Project No: 1321-15

Re: Global Switch east – Stage 2 – BCA review

Plans by DEM –

original	scale	drawn	project no.
b1	1:200	KK/MN	4277-00
drawing no.			rev no.
ar-1204			B05

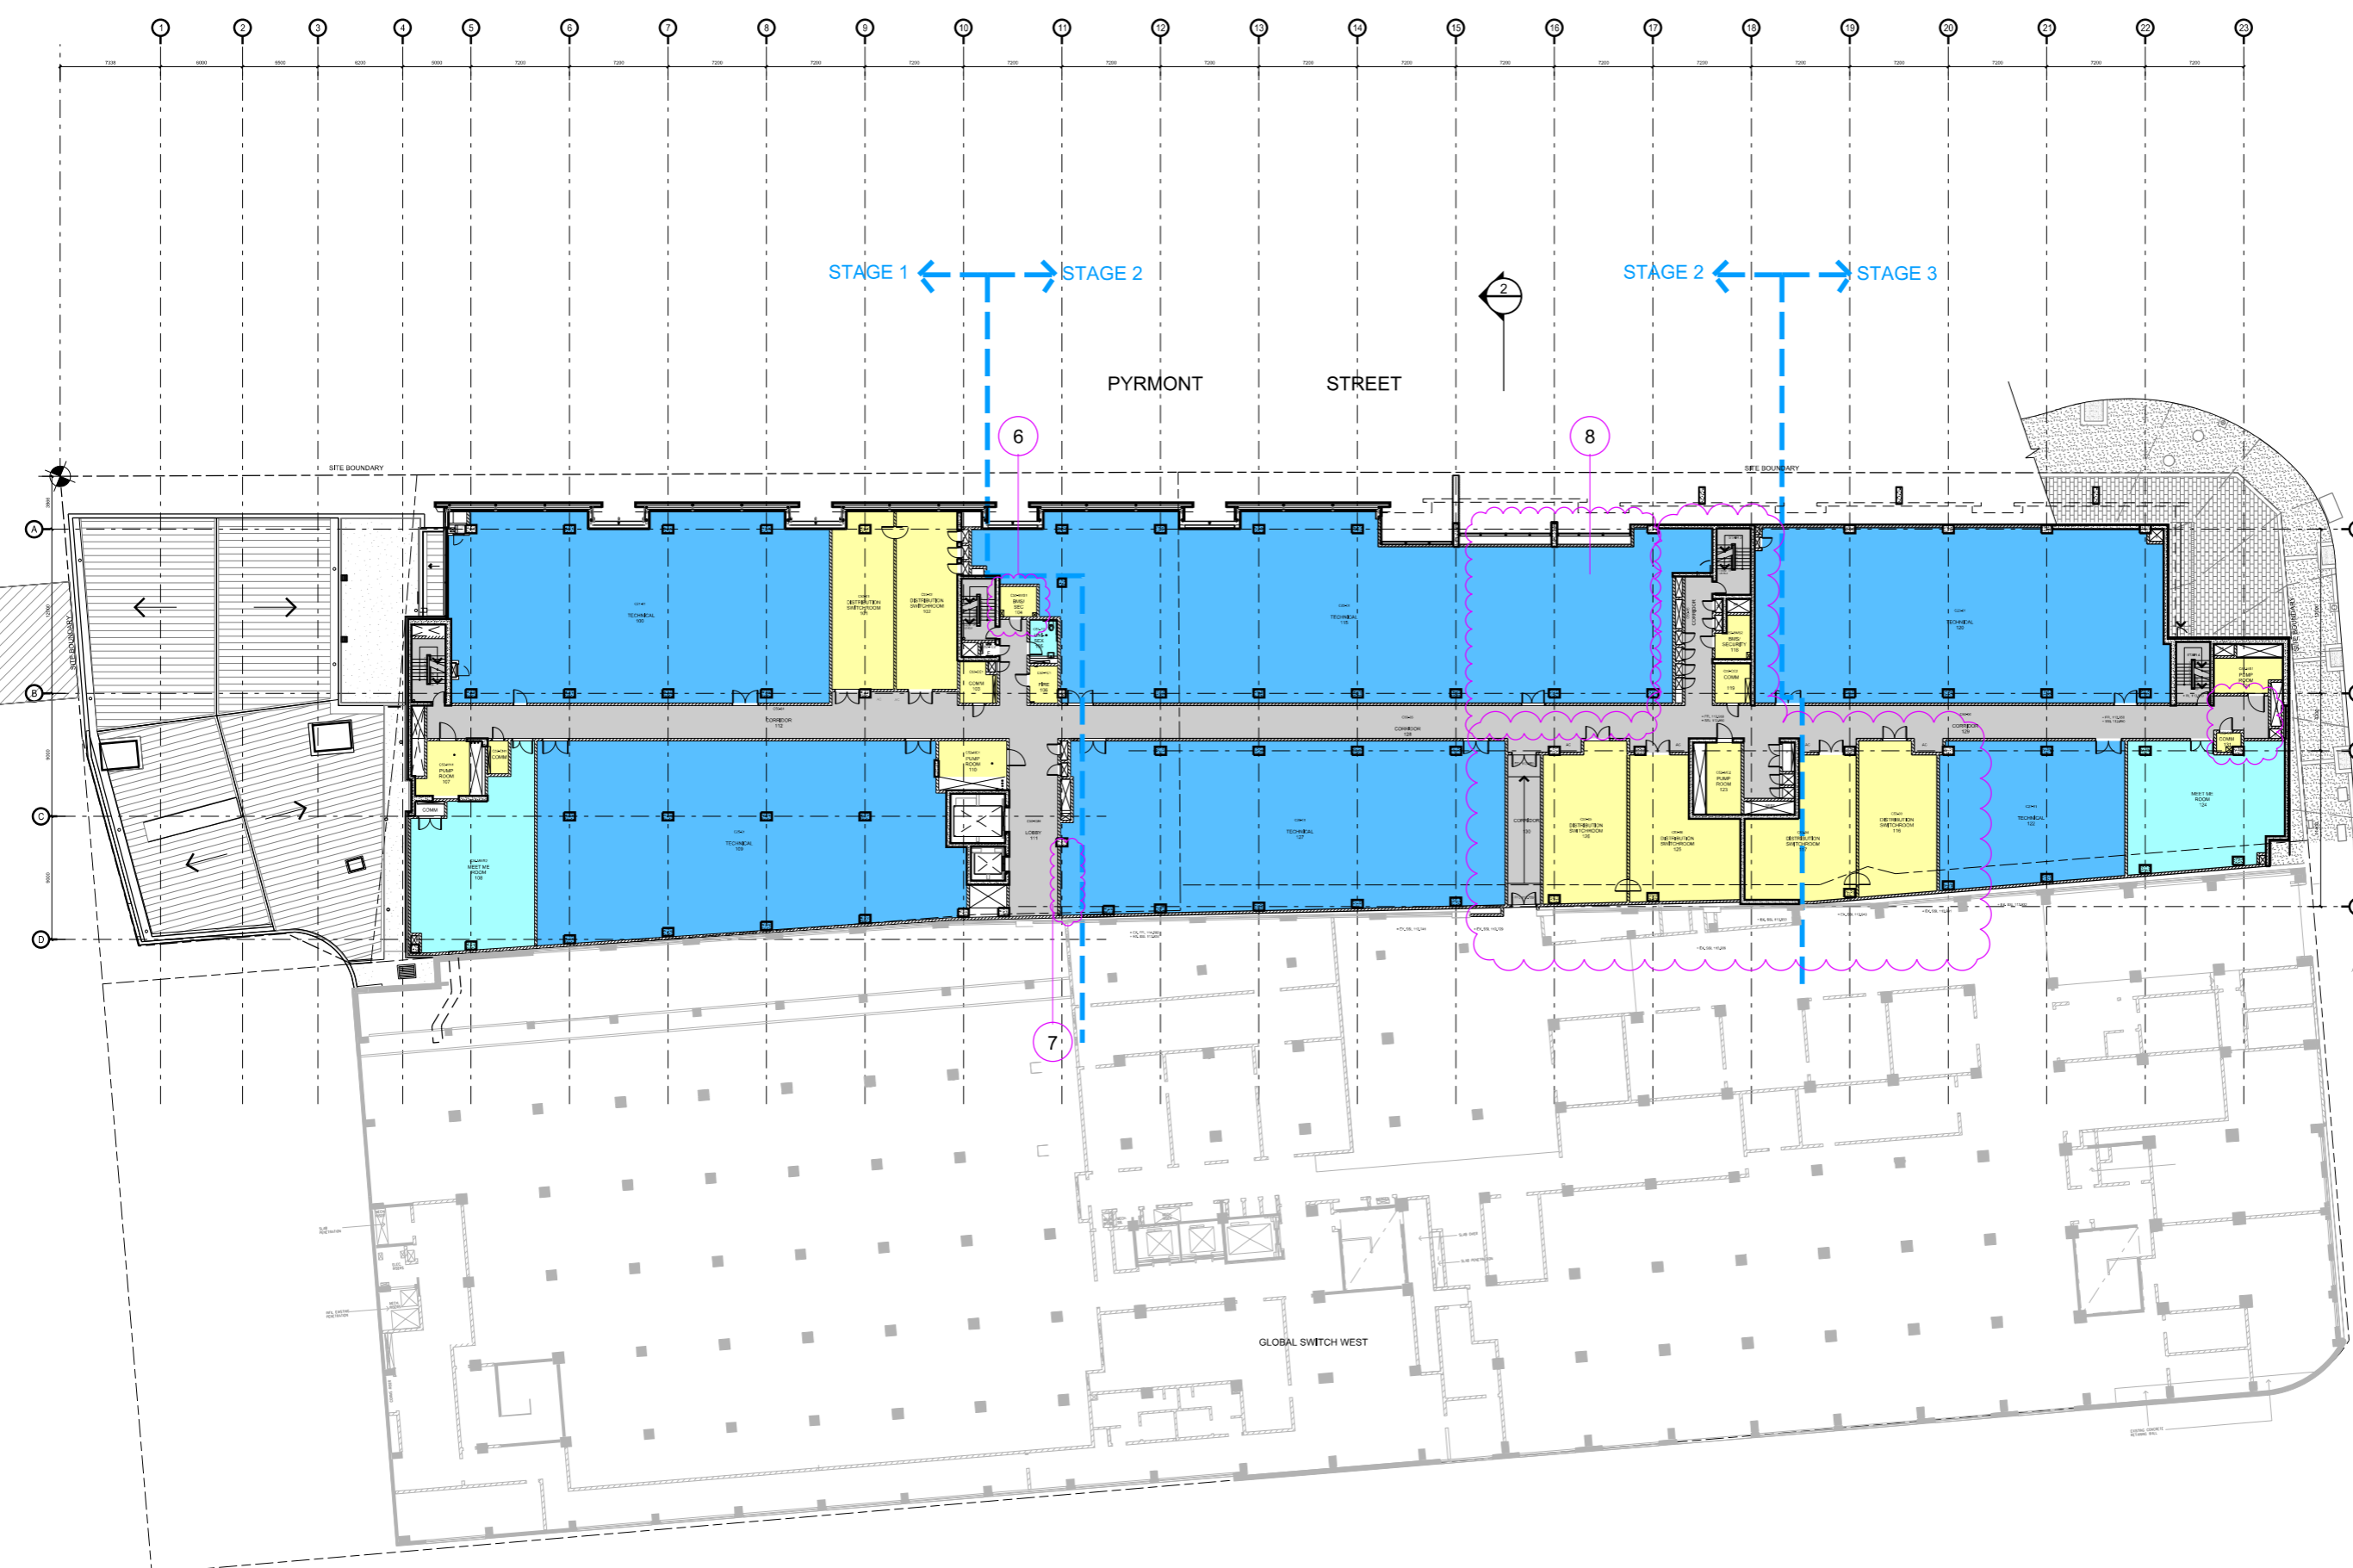
2. A Section 75W submission would be required for the removal of the meeting room, entry lobby security, WC and replacing it with data suite – level 0.
3. The new corridor on level 1 appears to connect into GSW. If so two hour fire separation would be required (wall and doors).
4. All access panels to air-intakes etc, in plat areas are required to be fixed not hinged, this was an issue on stage 1, for instance level 5 – grids 11-16. Otherwise travel distances in these areas will need to be considered by the fire engineer as they will not comply.
5. We note that due to the low occupant load of the building that the toilet facilities provided are compliant for the proposed population.

ar-1211 **B05**

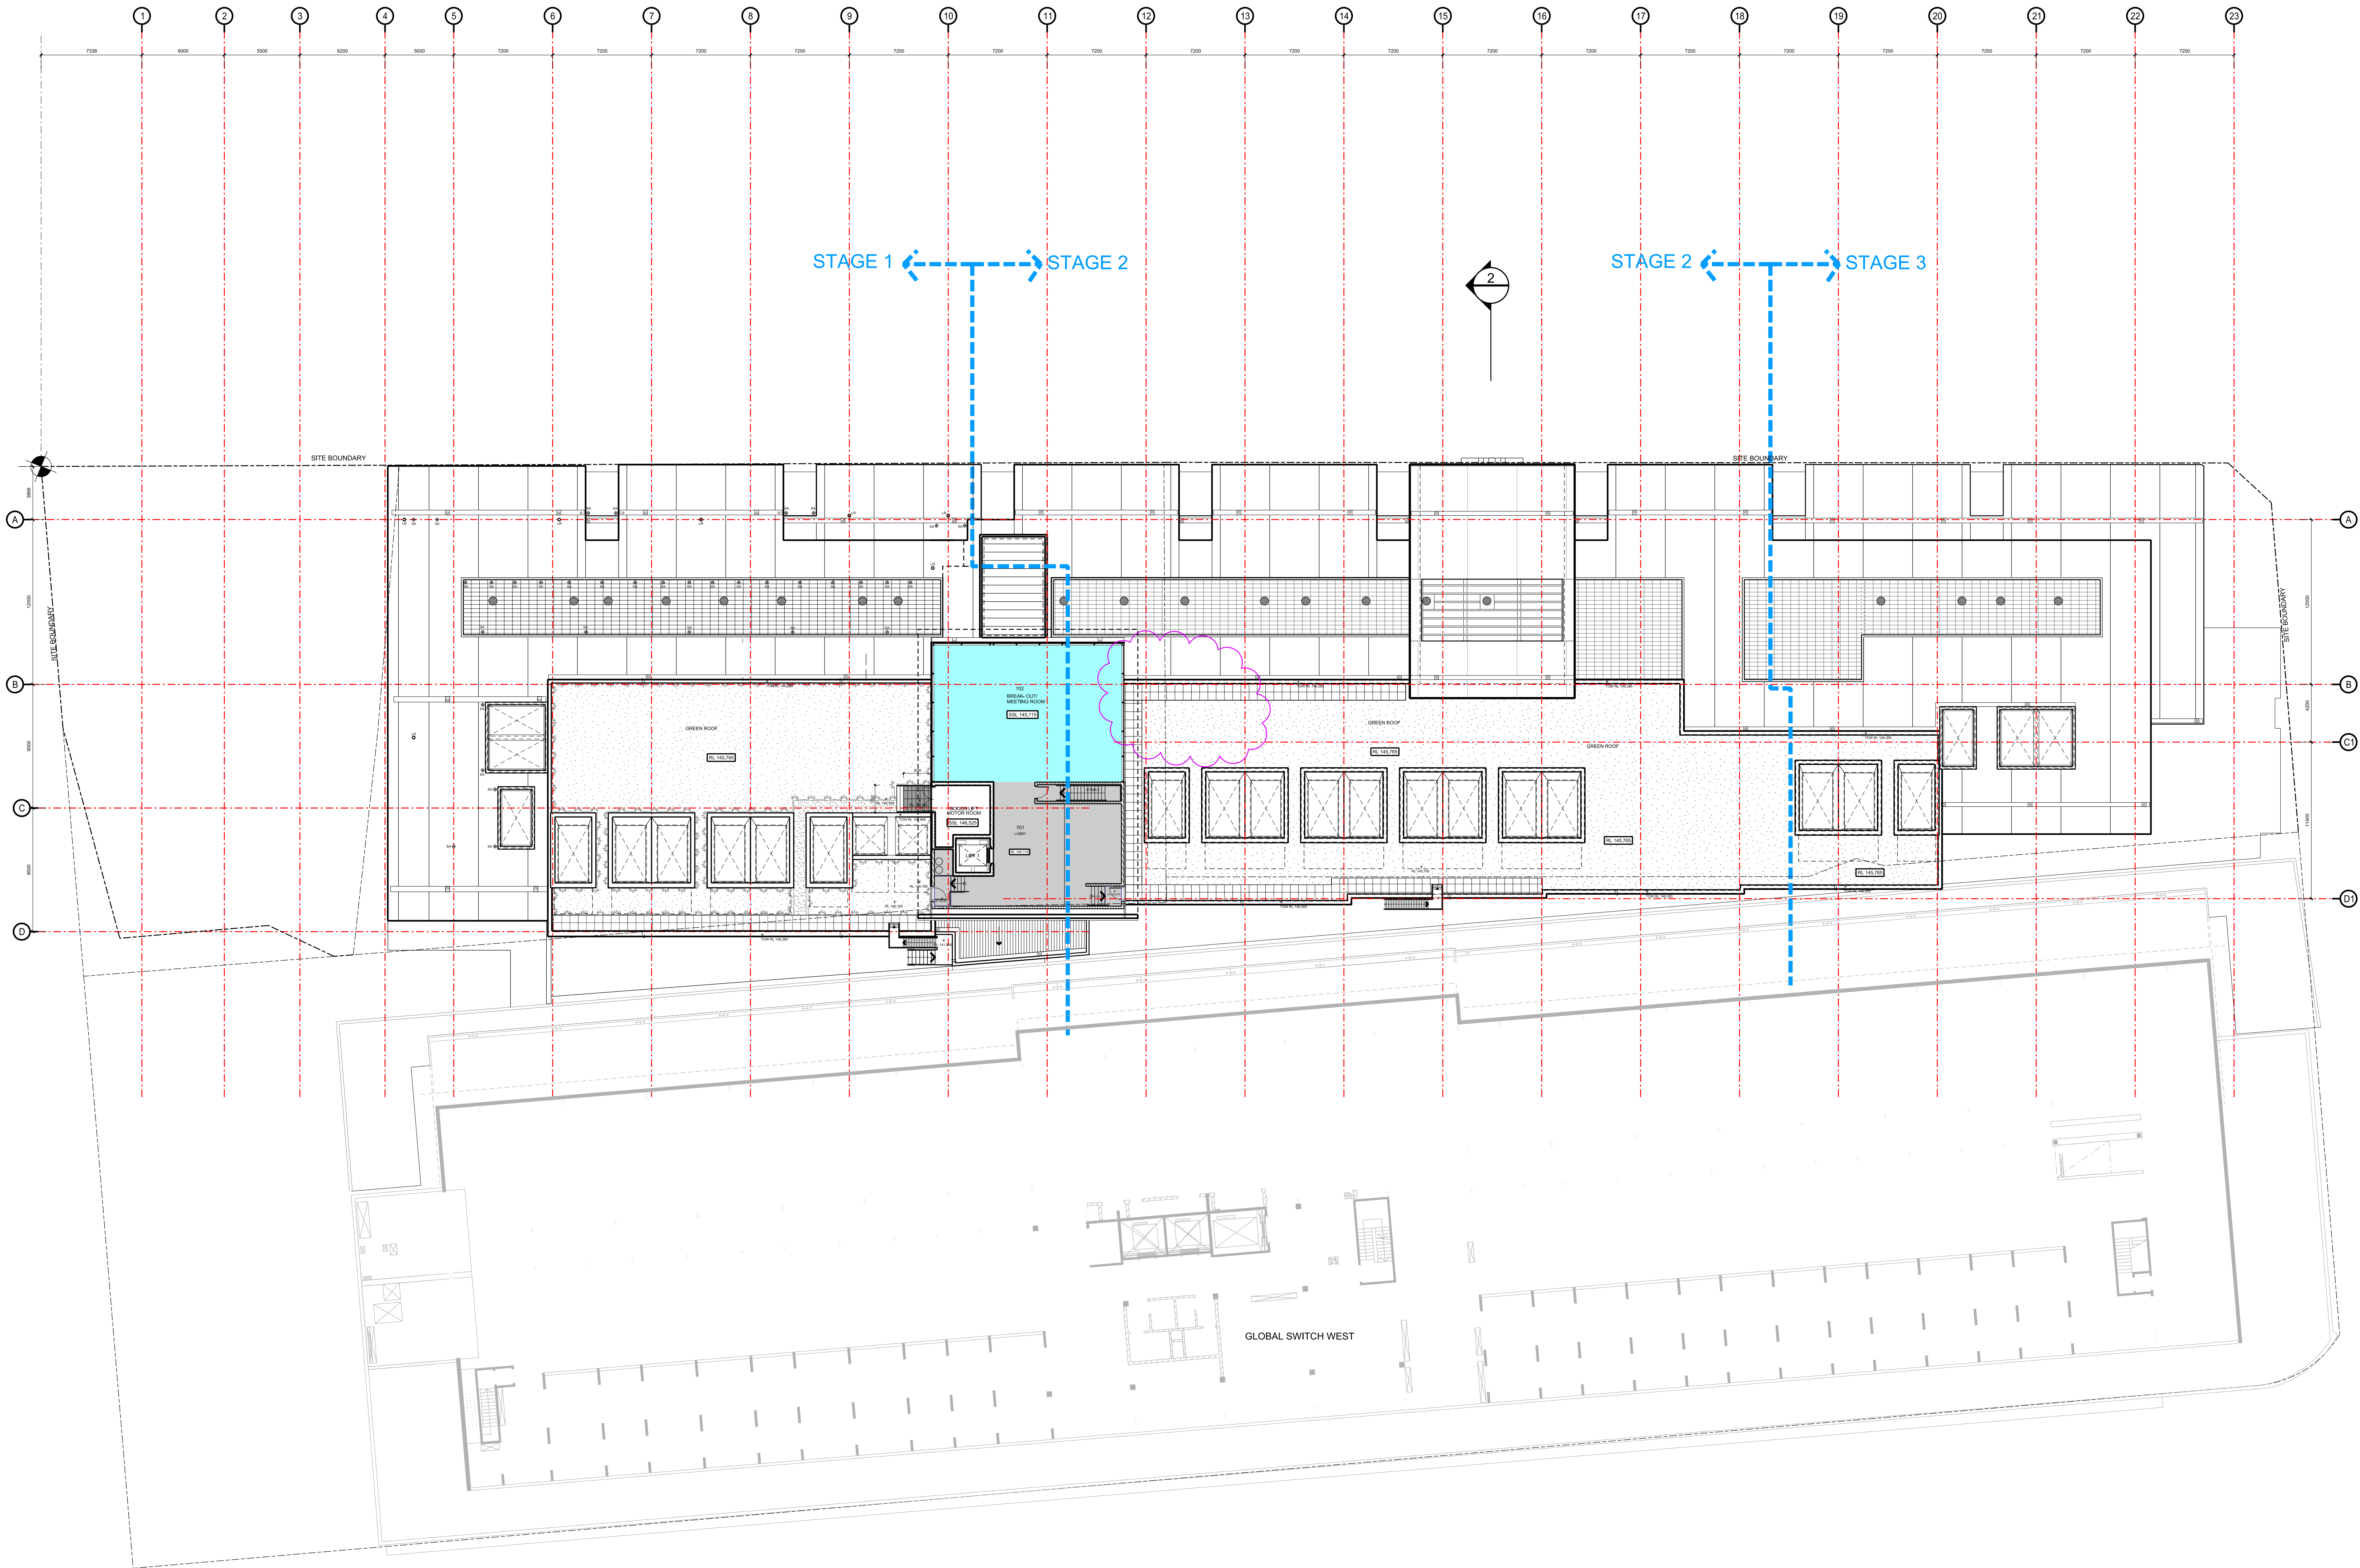
1. The design indicates access panel's within the basement that are hinged in nature not fixed. This would result in the plenum spaces being considered accessible from a BCA point of view. As such services would be required within these spaces, such as exit signage, emergency lighting etc. In addition travel distances would either need to be compliant or addressed via a performance based solution (noting it is circa 100-m between exits in the plenum on the eastern side.
